**RE: The Wymont  
4315 Wyoming Blvd NE  
Grading and Drainage Plans  
Engineer's Stamp Date: 01/27/22  
Hydrology File: G19D004**

**RE: The Wymont  
4315 Wyoming Blvd NE  
Grading and Drainage Plans (G19D004)**

Per the correspondence dated December 27, 2021, please find the following responses addressing the comments listed below:

NOTE

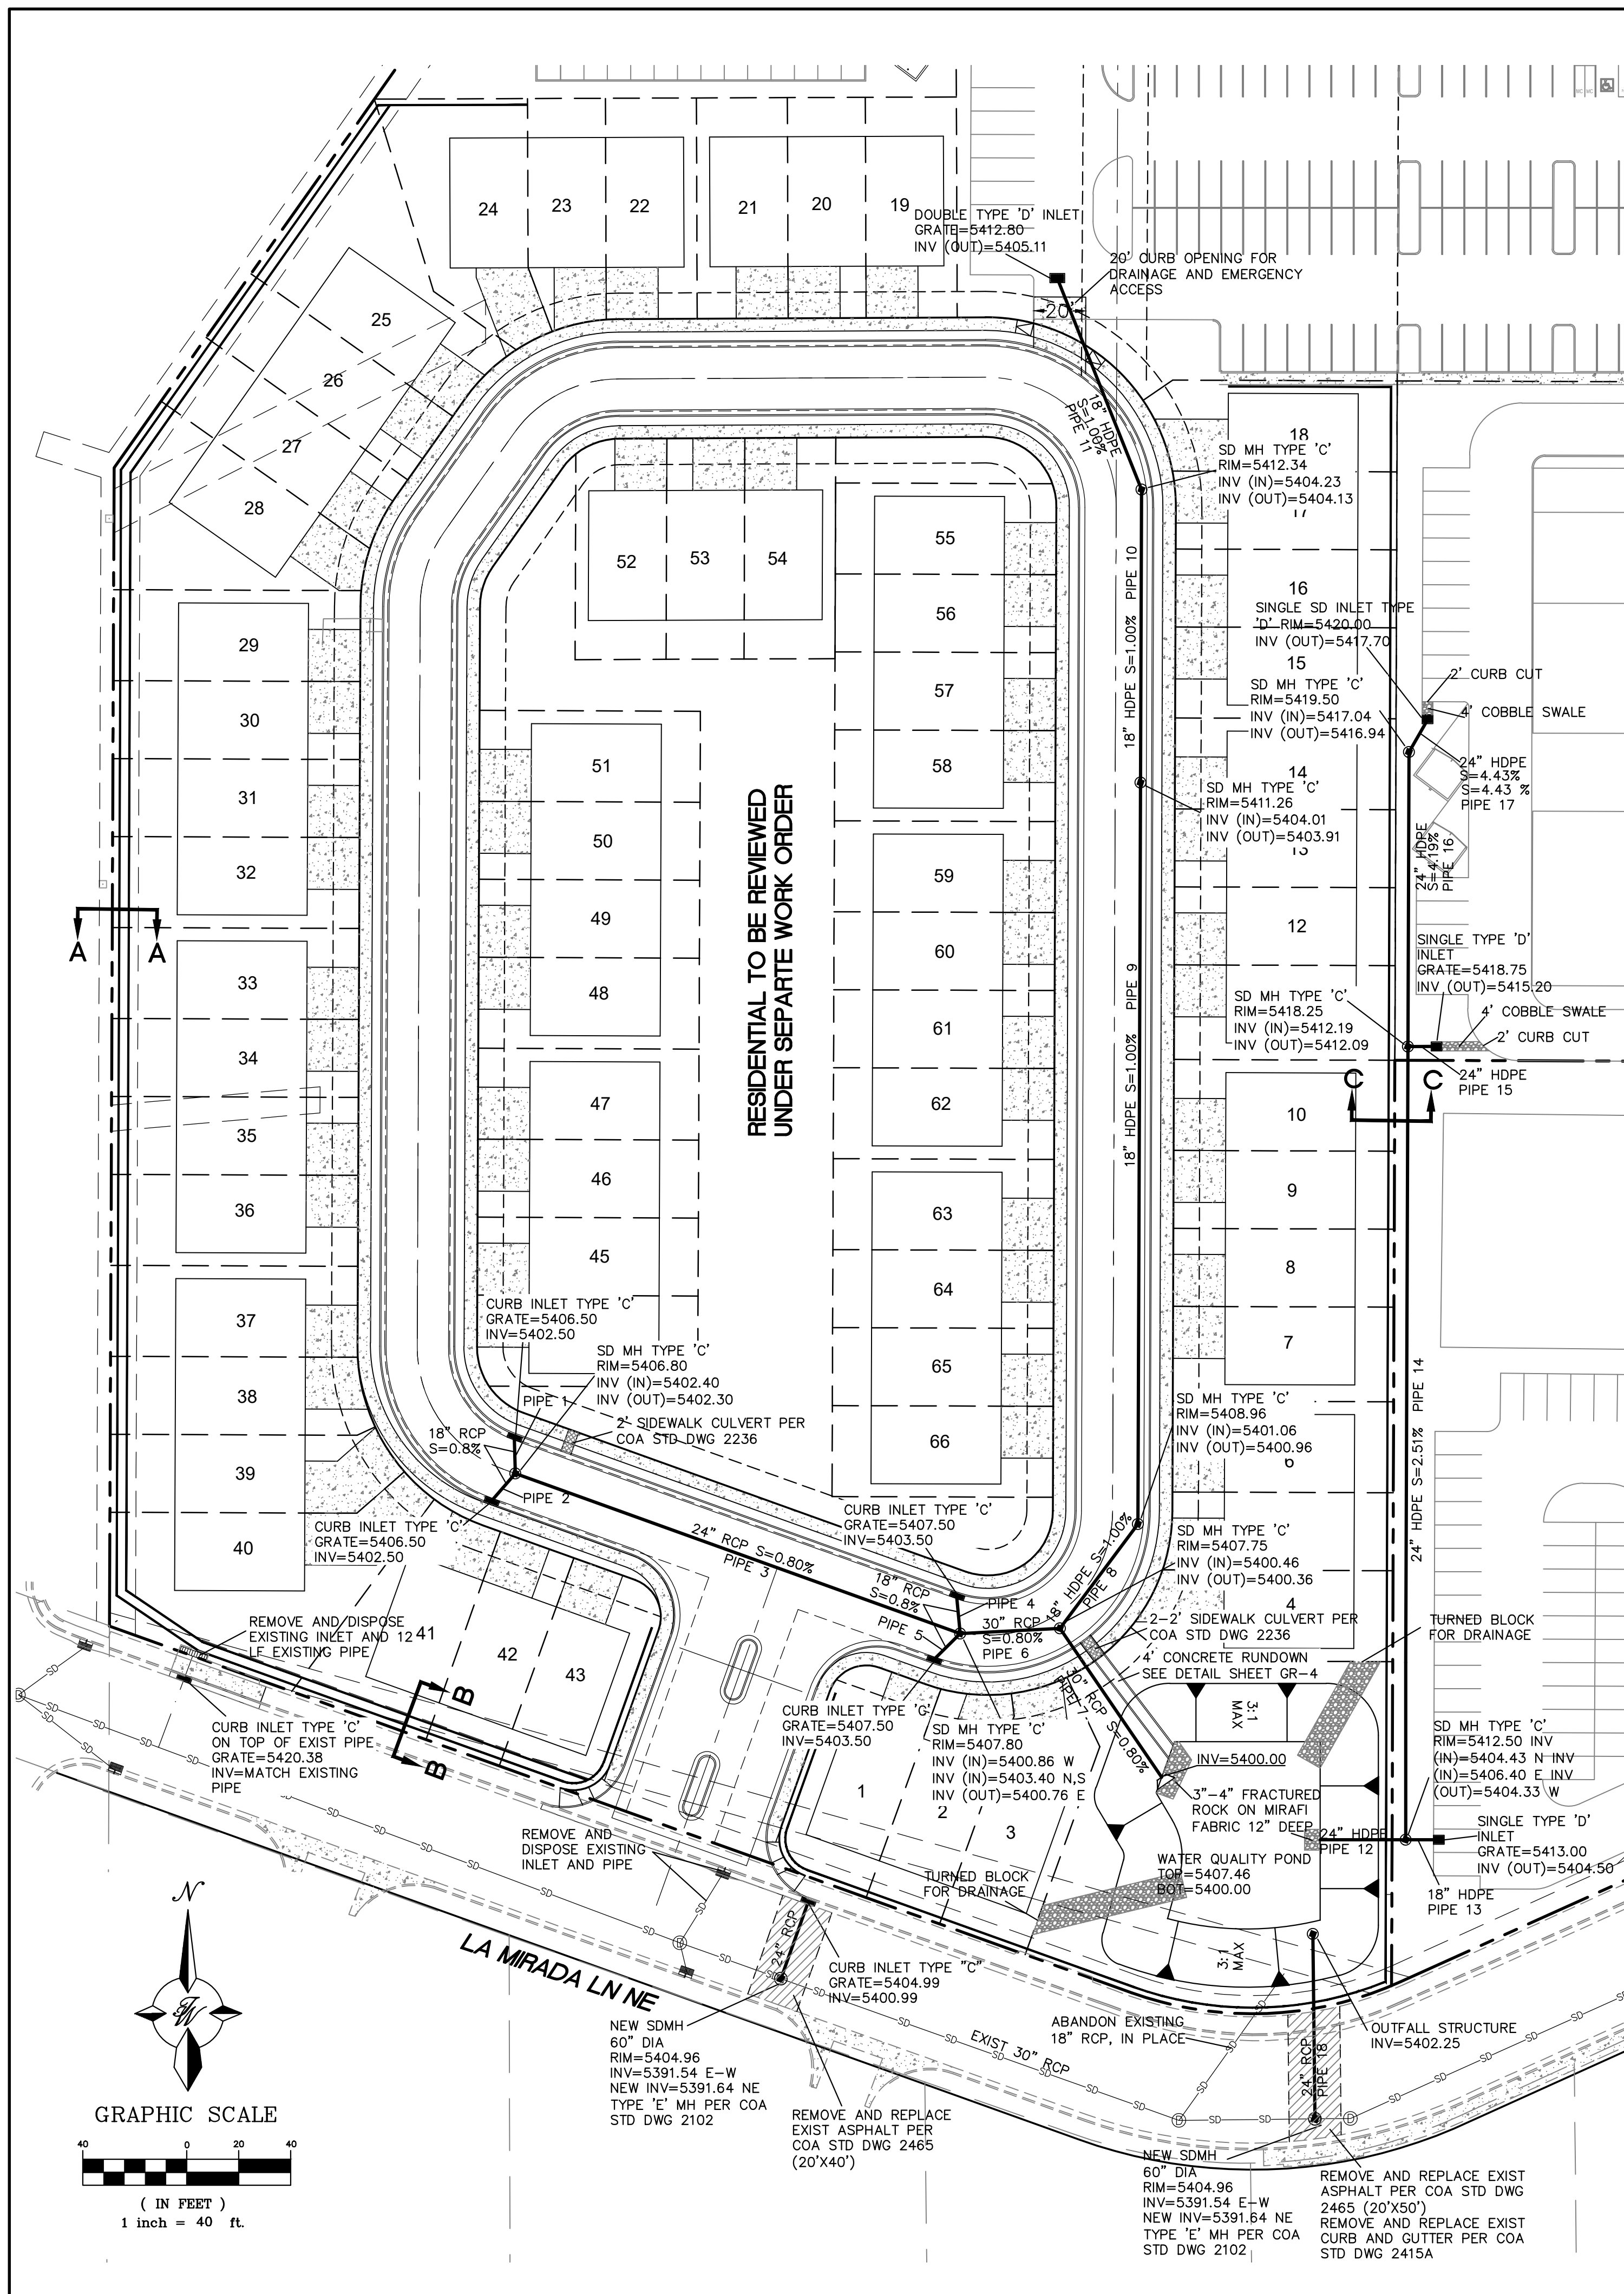
3. GR-1. This is currently very congested and difficult to read. Please, make this sheet just an overall Grading Plan with added pipe sizes, detention pond labeled, proposed contours, and line work with text showing which pipes and grading are to be done under which of the two work orders. **The sheet scale was increased to 1"=30' for better readability.**

4. GR-1. Please add a note, "Side slopes need to be stabilized with Native Grass Seed (per City Spec 1012) with Aggregate Mulch or equal (Must satisfy the "Final Stabilization criteria" CGP 2.2.14.b.)". This is for the water quality pond. **This note was added to the plan**

OUTFALL DETAIL
NTS

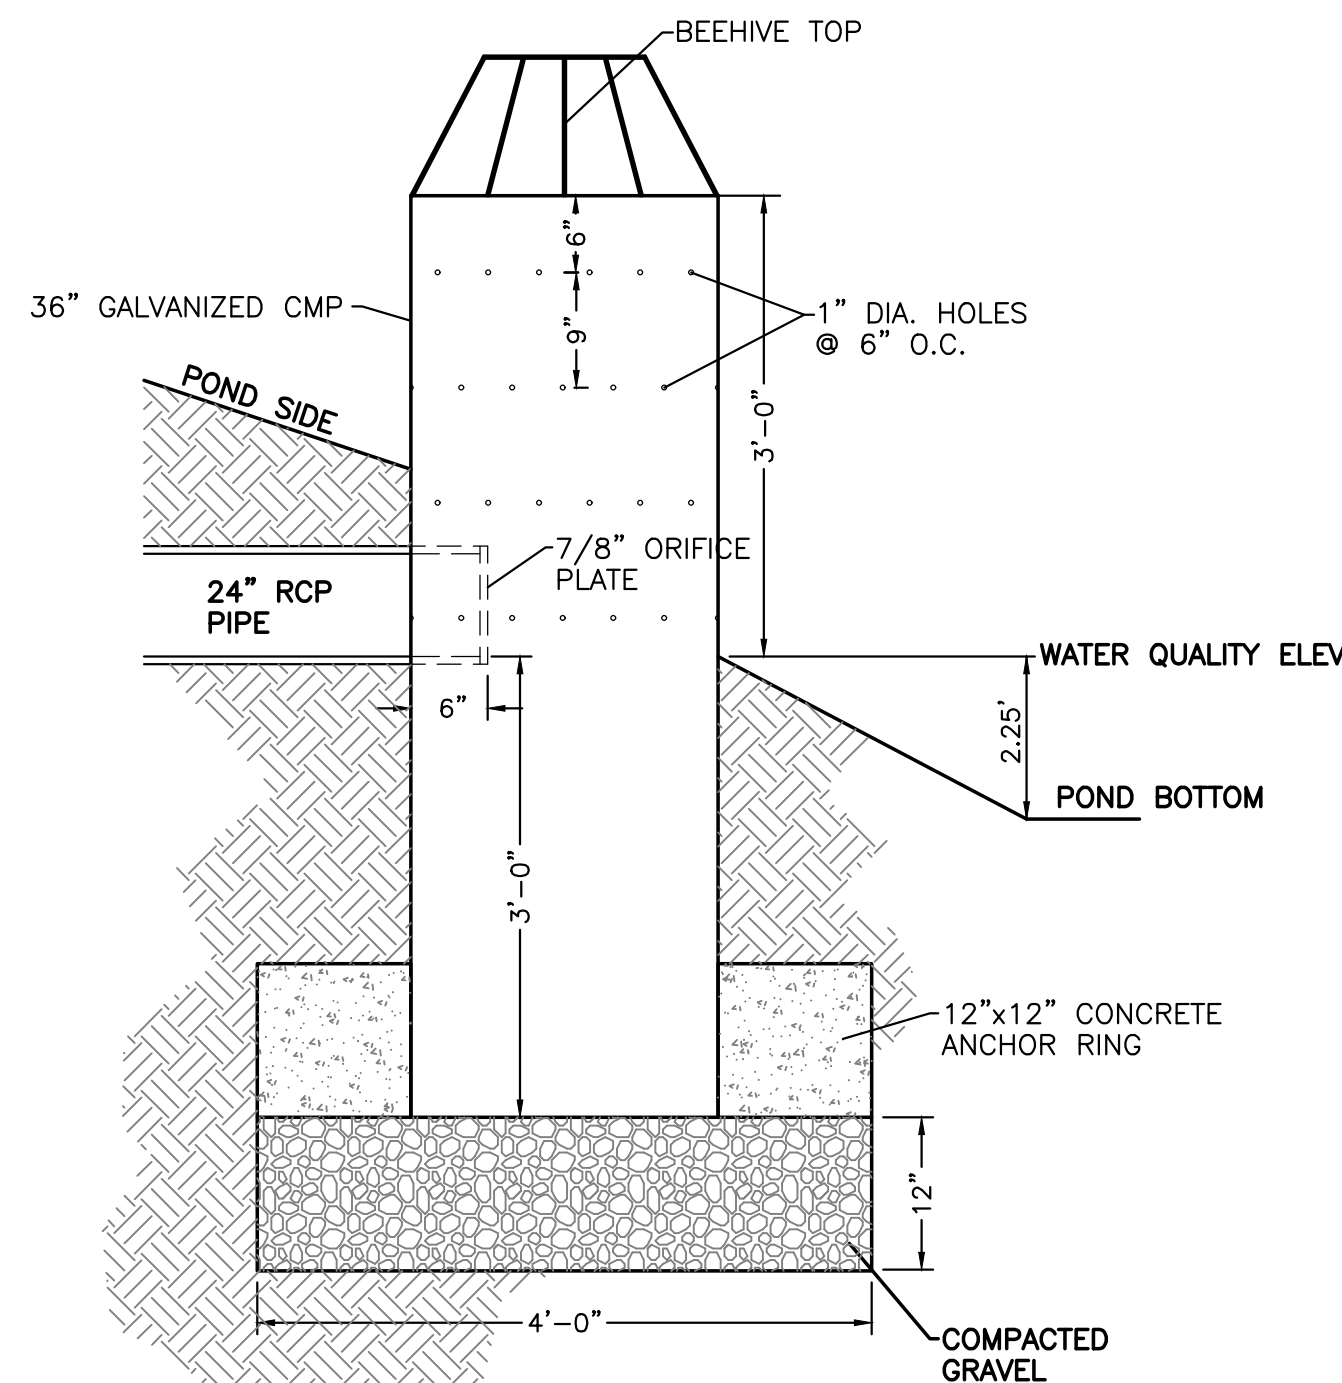
11. GR-4. Outfall Detail. Please provide the bottom of pond elevation, water quality elevation, top of pond elevation, and the elevation of the beehive top. **This information is now included on the outfall detail now found on Sheet GR-8.**
